Our Case Number: ABP-317780-23

Your Reference: Rathmichael Parish School

Re: Bray to City Centre Core Bus Corridor Scheme Compulsory Purchase Order 2023
Bray to Dublin City Centre

BusConnects Bray to City Centre Core Bus Corridor Scheme
An Bord Pleanála Case Reference: HA27.317742

Figure 2: Location of approved outdoor classroom

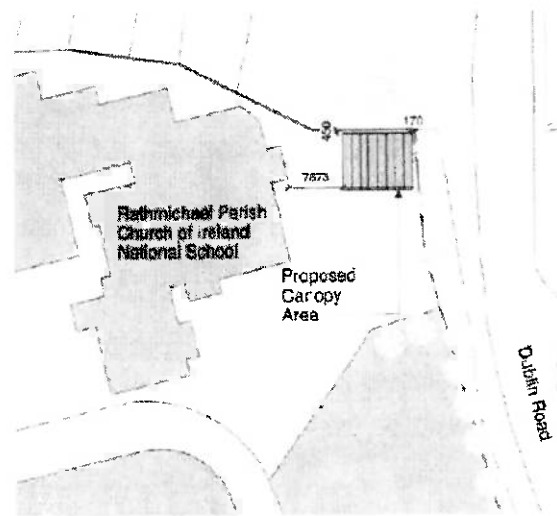
It should also be noted that planning permission was granted in May 2023 for the construction of an outdoor canopy for an outdoor classroom the north eastern corner of site immediately adjacent to the construction area (in location 6 in Figure 1 above). The existence of this proposal has not been factored into the Scheme design and the Board would require that its construction is not impacted by the Scheme.

Figure 3: Extract of Map 44: Emerging Preferred Route February 2019 (NTA)

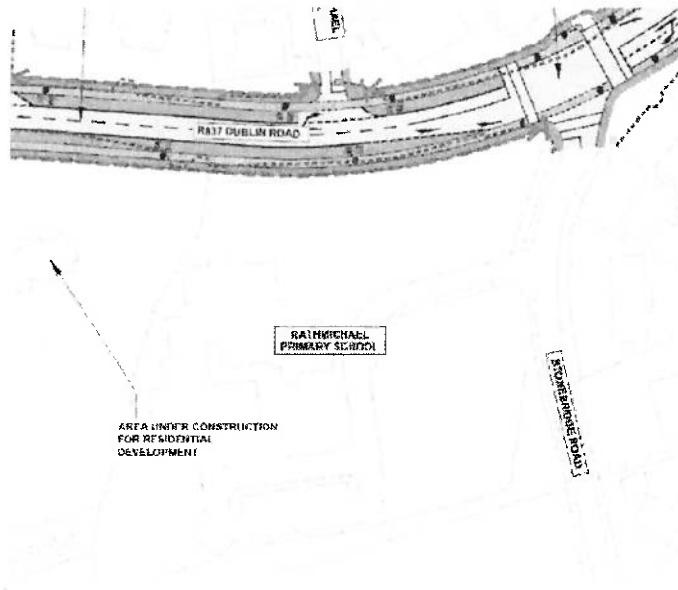
The Emerging Preferred Route that was the subject of public consultation in February 2019 indicated that one bus lane, one general traffic lane and a single segregated cycle track was to be provided in each direction on Dublin Road to St Anne's Church to the south. It was further indicated that the existing Dublin Road/Stonebridge Road junction was intended to be upgraded to facilitate bus priority. (See Figure 3 overleaf.)

Figure 4: Extract of Map 44: Preferred Route March 2020 (NTA)

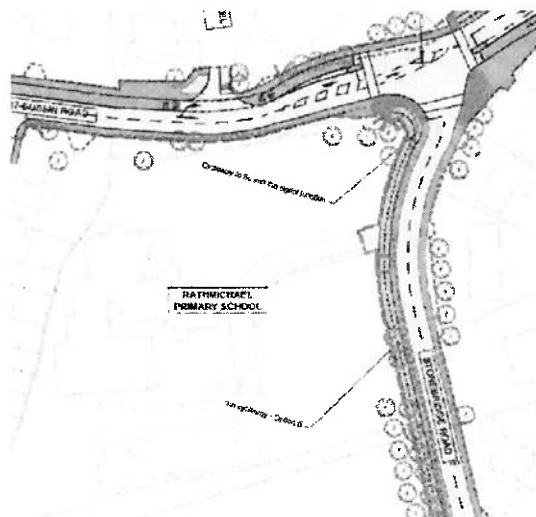
As a consequence of the consultation process, the Emerging Preferred Route was changed - the segregated cycle tracks on Dublin Road between Loughlinstown Roundabout and Stonebridge Road were omitted and a two-way cycle track from the Shanganagh Road/Dublin Road Junction along the Dublin Road and along Stonebridge Road as far as St Anne's National School was included to provide a local cycle link to the two schools. The NTA stated that *"these proposals have been introduced following local community engagement and consideration of submissions from the public."* (See Figure 4 below).

The fact that the tracks are proposed as a consequence for local consultation and did not form part of the published Emerging Preferred Route, they are clearly not integral to the achievement of the overall Scheme objectives.

Figure 5: Proposed cycle tracks (highlighted in blue)

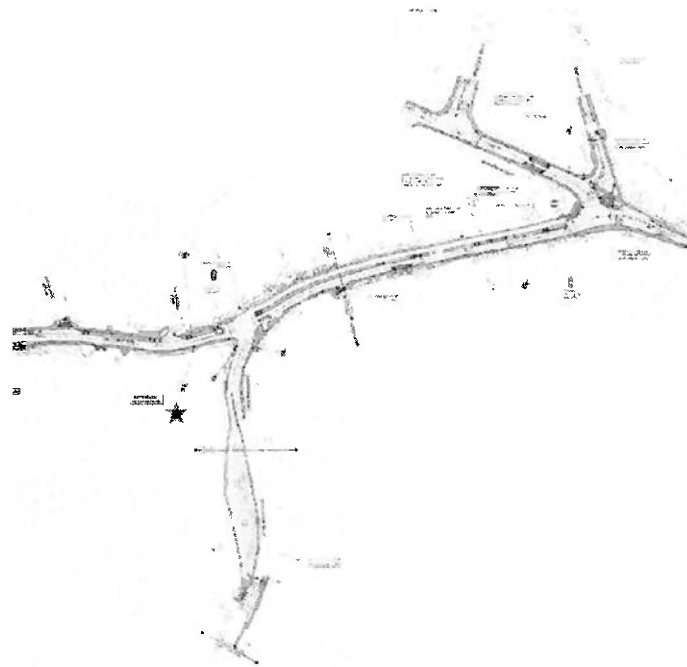
The utility of the proposed cycle tracks and the achievement of their stated purpose are questioned. As shown in Figure 5 below the cycle tracks do not link the two schools to the wider area. There are no segregated tracks on Dublin Road – these were omitted from the Emerging Preferred Route; at the proposed reconfigured Corbawn Lane/Dublin Road junction the very short section of cycle track on Corbawn Lane is separated from the track on the eastern side of Dublin Road by a pedestrian priority zone; and there are no segregated tracks along Corbawn Lane or along Dublin Road through the village centre.

The proposed cycle tracks do not form part of a larger network and whose benefit to connectivity in the wider area has not been assessed or justified in the Scheme.

The impact of the land take to provide the tracks, which falls exclusively and disproportionately on the school, will be substantial and having regard to the above is not required and therefore unjustified.

The Board considers that the proposal in the Scheme to provide cycle tracks along the northern side of Stonebridge Road must be reconsidered and should be reviewed with a view to omitting them from the overall Scheme as their benefit to connectivity in the wider area has not been assessed or justified in the Scheme.
